**WELWYN HATFIELD BOROUGH COUNCIL
EXECUTIVE DIRECTOR - PLANNING, PUBLIC PROTECTION AND GOVERNANCE**

DELEGATED APPLICATION

Application No: 6/2017/2957/HOUSE
Location: Wildewood Kentish Lane Brookmans Park Hatfield AL9 6JG
Proposal: Erection of ground floor extension & construction of a basement following evacuation and demolition of existing pool area and removal of external paving and terraced areas
Officer: Ms Lucy Hale

Recommendation: Refused

DRAWING TITLE
 PROPOSED BASEMENT
 AND GROUND FLOOR
 PLANS

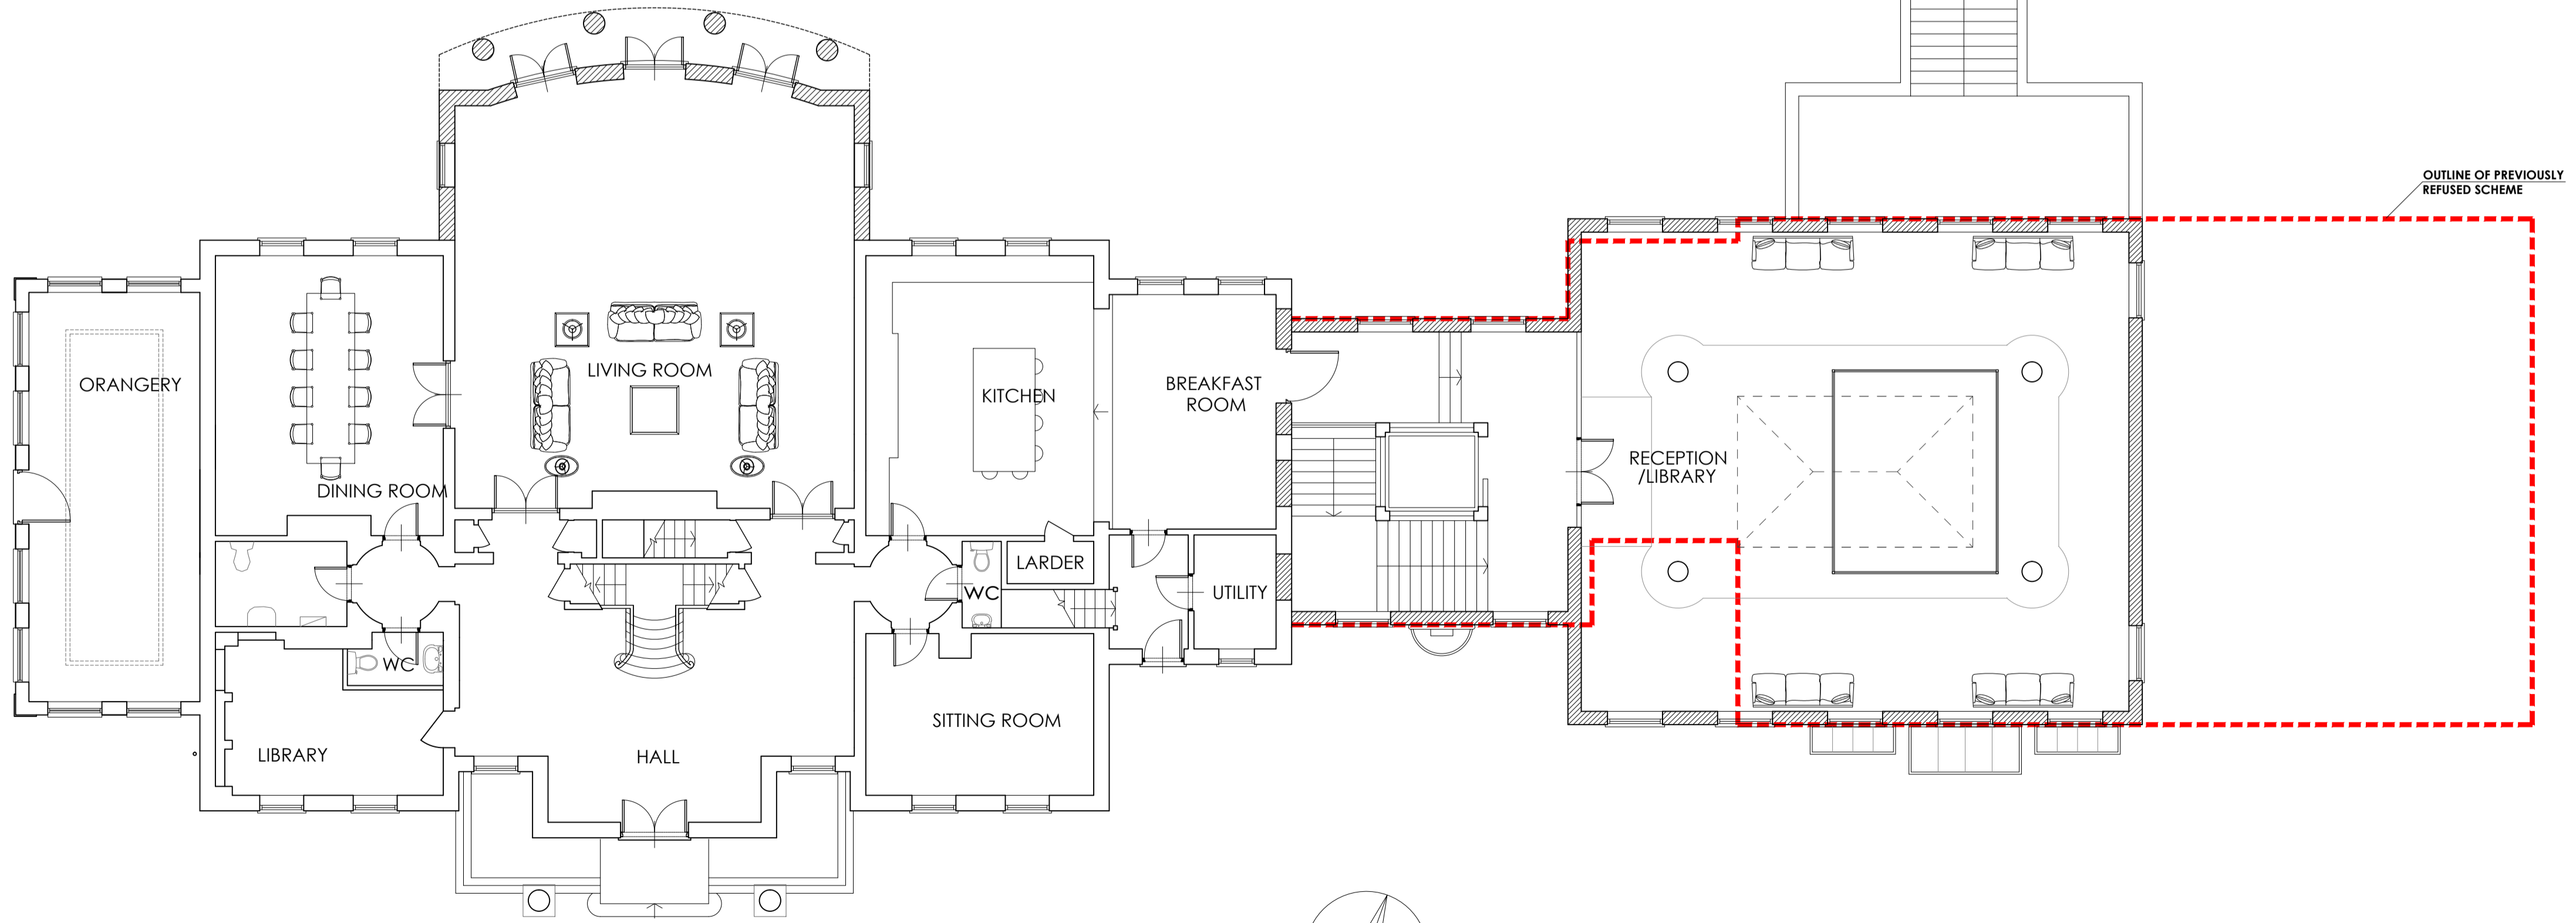
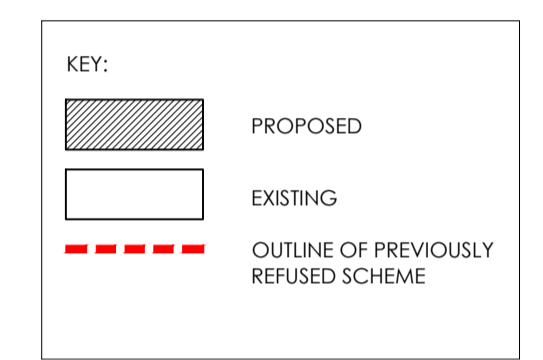
also taken into consideration. The extension is of single storey nature and the height has been minimised where possible by virtue of design, however, the width of the extension would measure approximately 19m. When taking into consideration the existing extensions to the dwelling, the combined width would more than double the width of the original dwelling. As a result of its width and bulk, the side extension would result in a substantial addition to the original dwelling.

In terms of the effect of the side extension on the openness of the Green Belt, the proposed increase in volume would materially increase the bulk and mass of development on the site thereby reducing the openness of the Green Belt. Notwithstanding this, the new extension would be concealed from view from the highway by extensive boundary vegetation within the site and along the roadside verge. For this reason, in determining the S6/2012/1258/MA planning application, the Local Planning Authority considered that the proposal would not have an adverse impact on the character and appearance of the surrounding countryside and would therefore accord with the second criterion of Local Plan Policy RA3.

The proposal has altered since the 2012 application. The application previously sought permission for a similar proposal which was detached from the dwelling. The application proposes an extension of similar depth and form to the 2012 application. The extension would result in a greater bulk and mass on site and it is considered that the presence of such an extension of this size would detract from the openness of the Green Belt and thereby conflict with one of its essential characteristics.

1. The proposed development would result in disproportionate additions over and above the size of the original building and is therefore inappropriate development within the Green Belt. Furthermore, the increased footprint and bulk of the building would result in a loss of openness of the Green Belt. Very special circumstances do not exist as the potential harm to the Green Belt is not clearly outweighed by other considerations. Accordingly, the proposal is contrary to Policy RA3 of the Welwyn Hatfield District Plan 2005, Supplementary Design Guidance 2005, the National Planning Policy Framework 2012 and Policy SADM 34 Draft Local Plan Proposed Submission 2016.
